KITITAS COUNTY

DEPARTMENT OF PUBLIC WORKS

MEMORANDUM

TO: All Staff
FROM: Zachery Peebles, Engineering Technician I
DATE: April 27, 2021
SUBJECT: BL-21-00006 Mundy

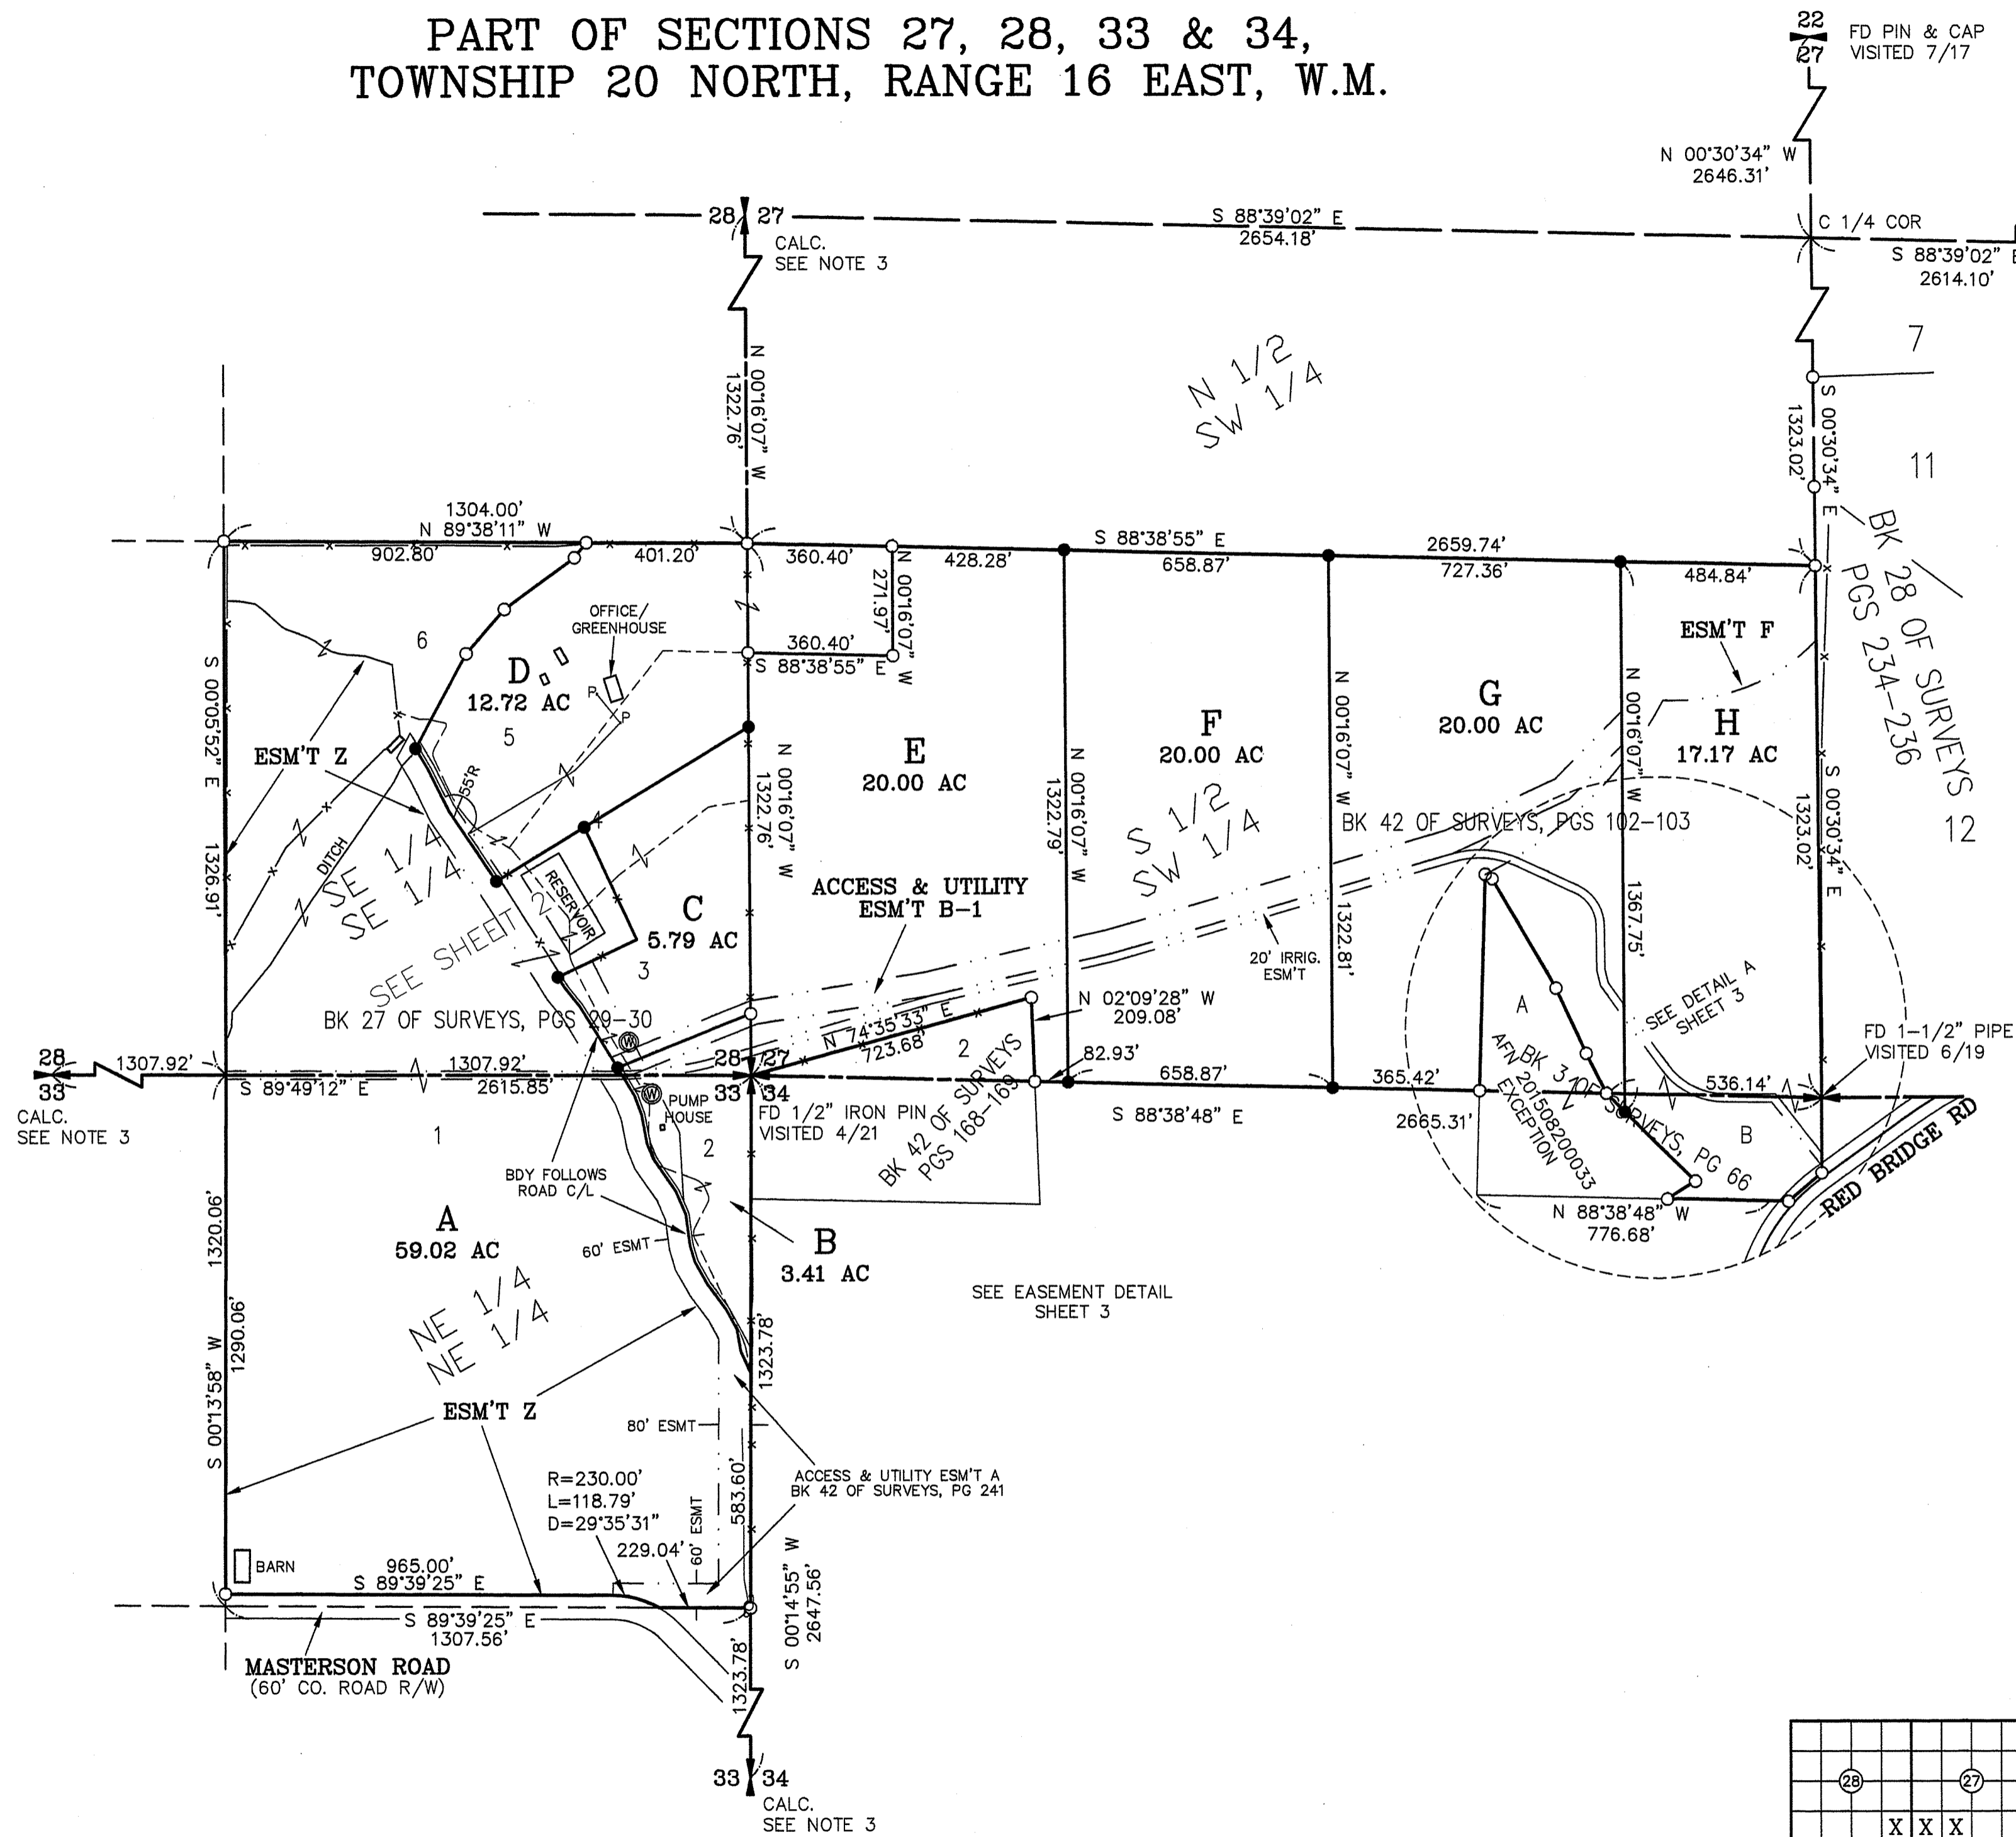
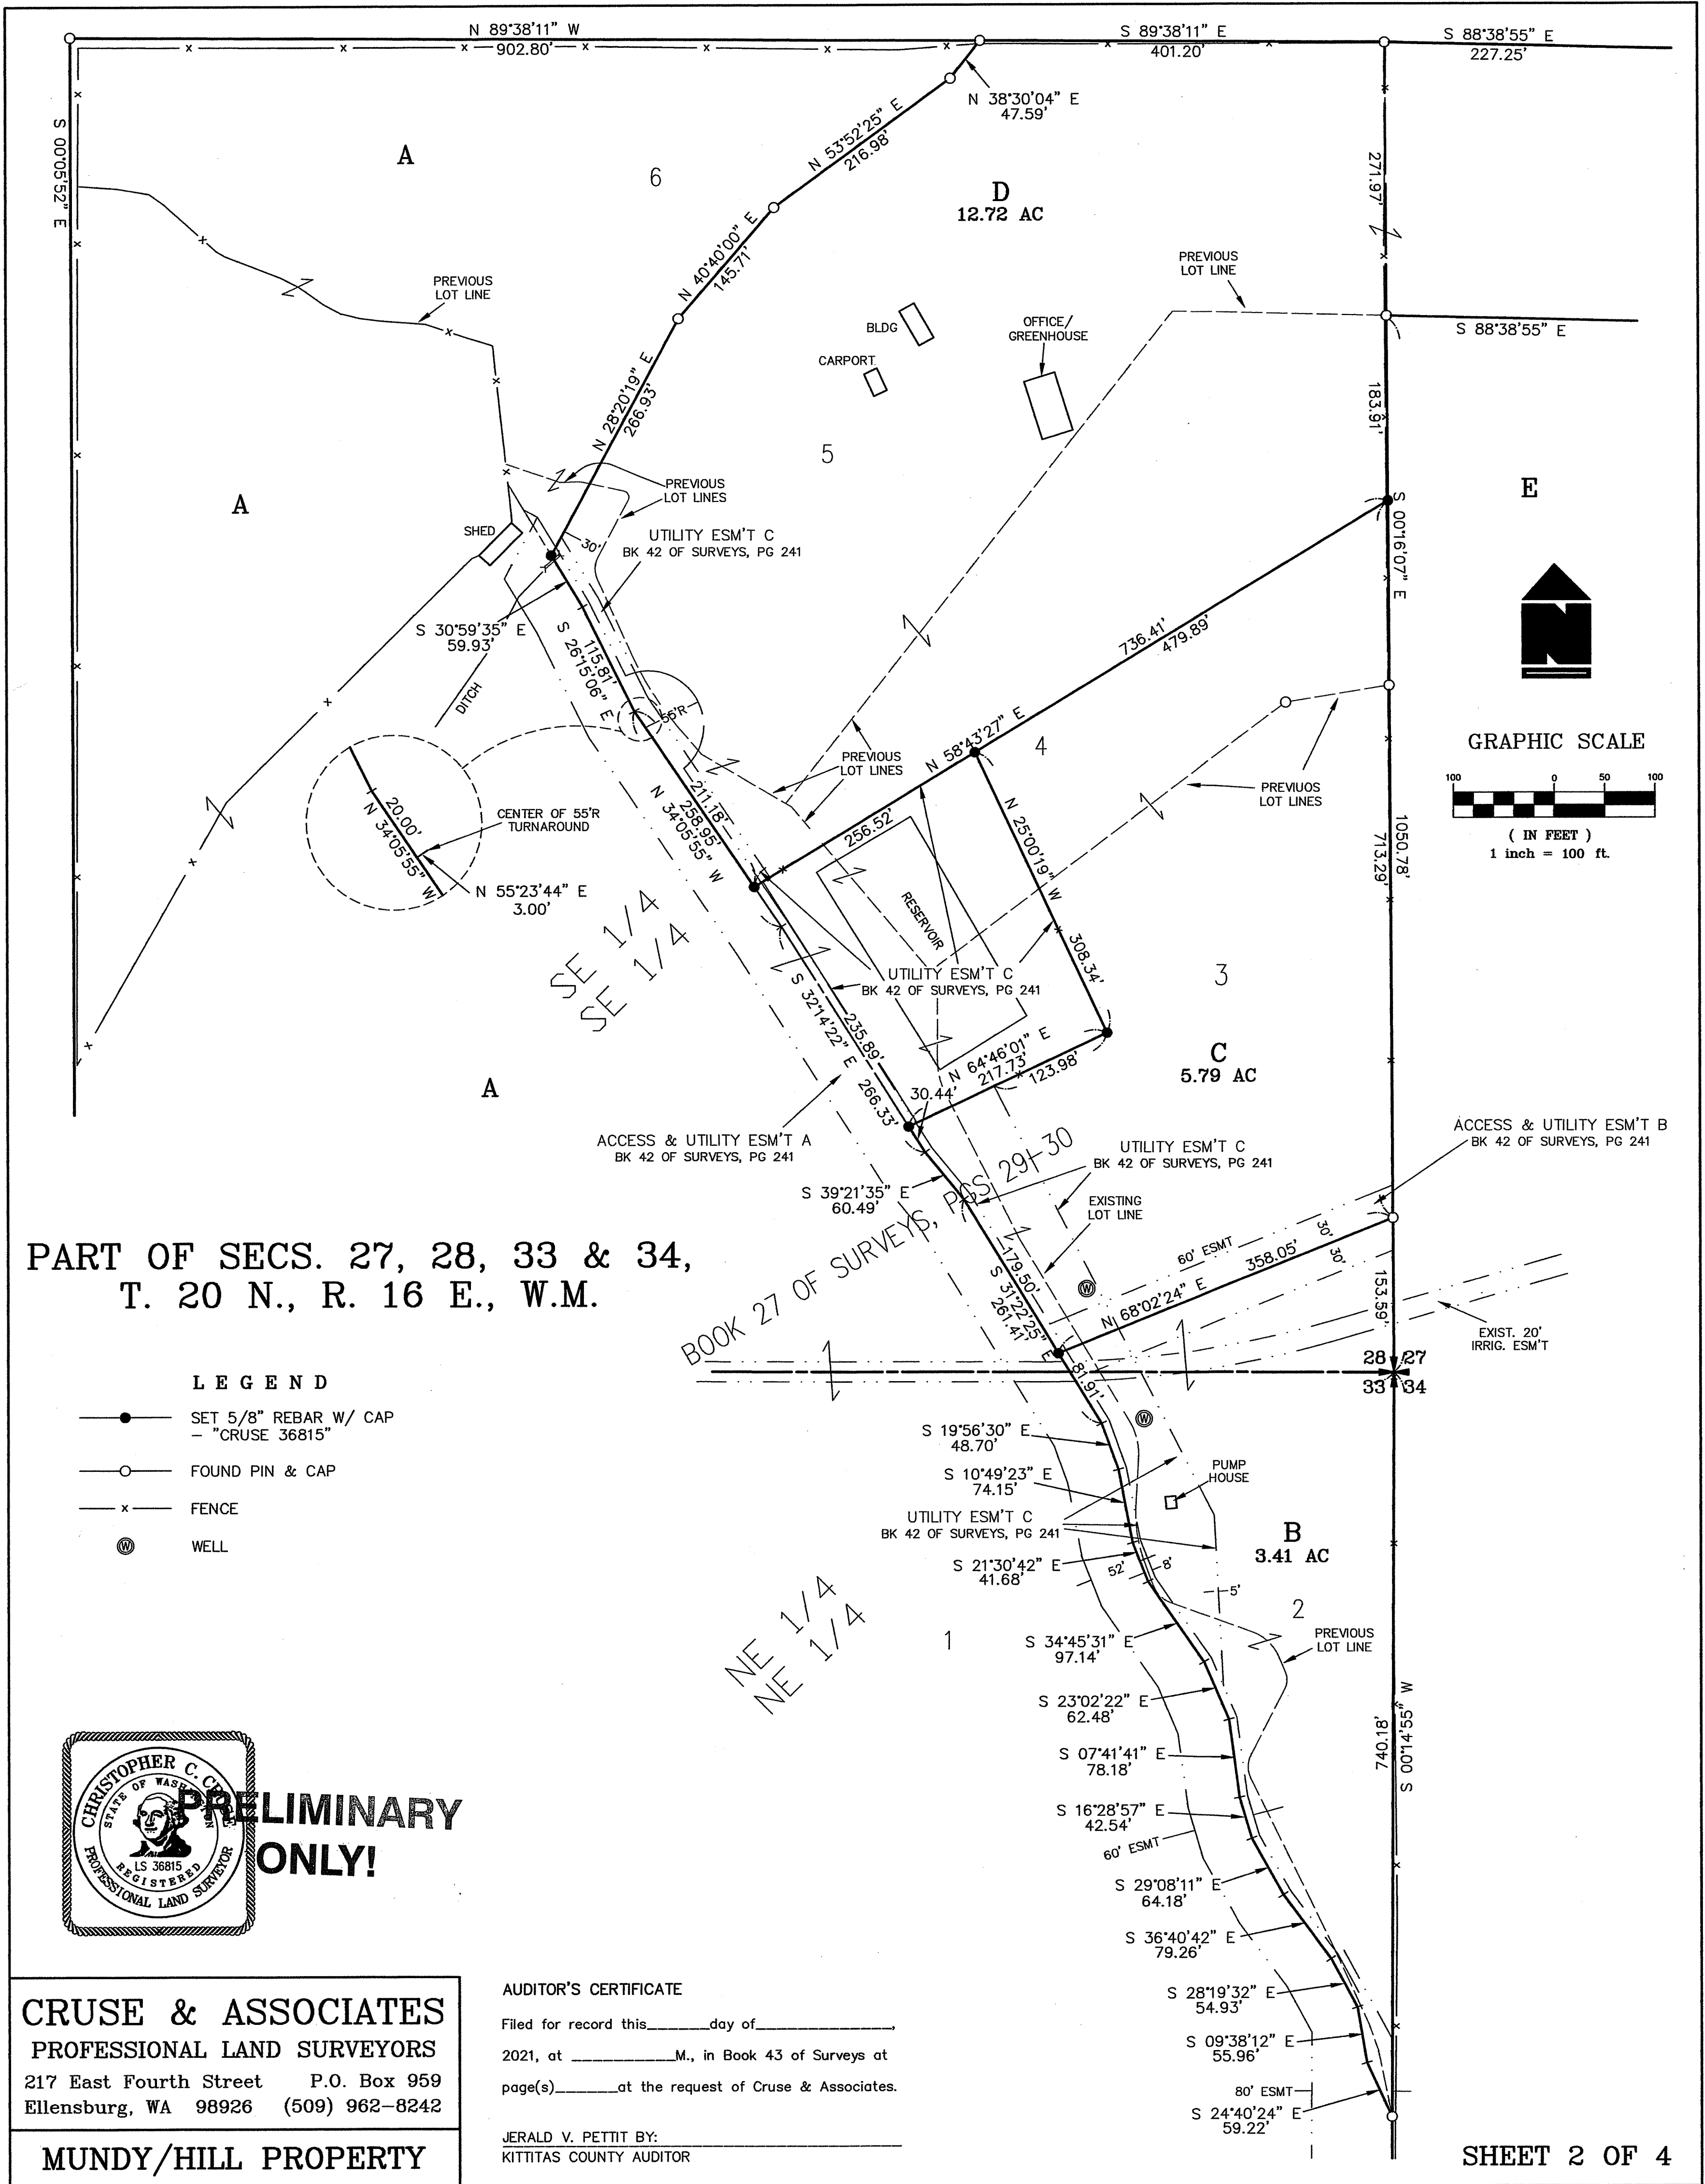
1. A revised legal description that describes the final configuration of the subject property shall be required.
2. A survey map is required for review. Any comments on the survey map will be reserved for final.
3. Please show all access easements on the face of the BLA.
4. Please provide a recorded copy of the proposed 60' driveway easement.
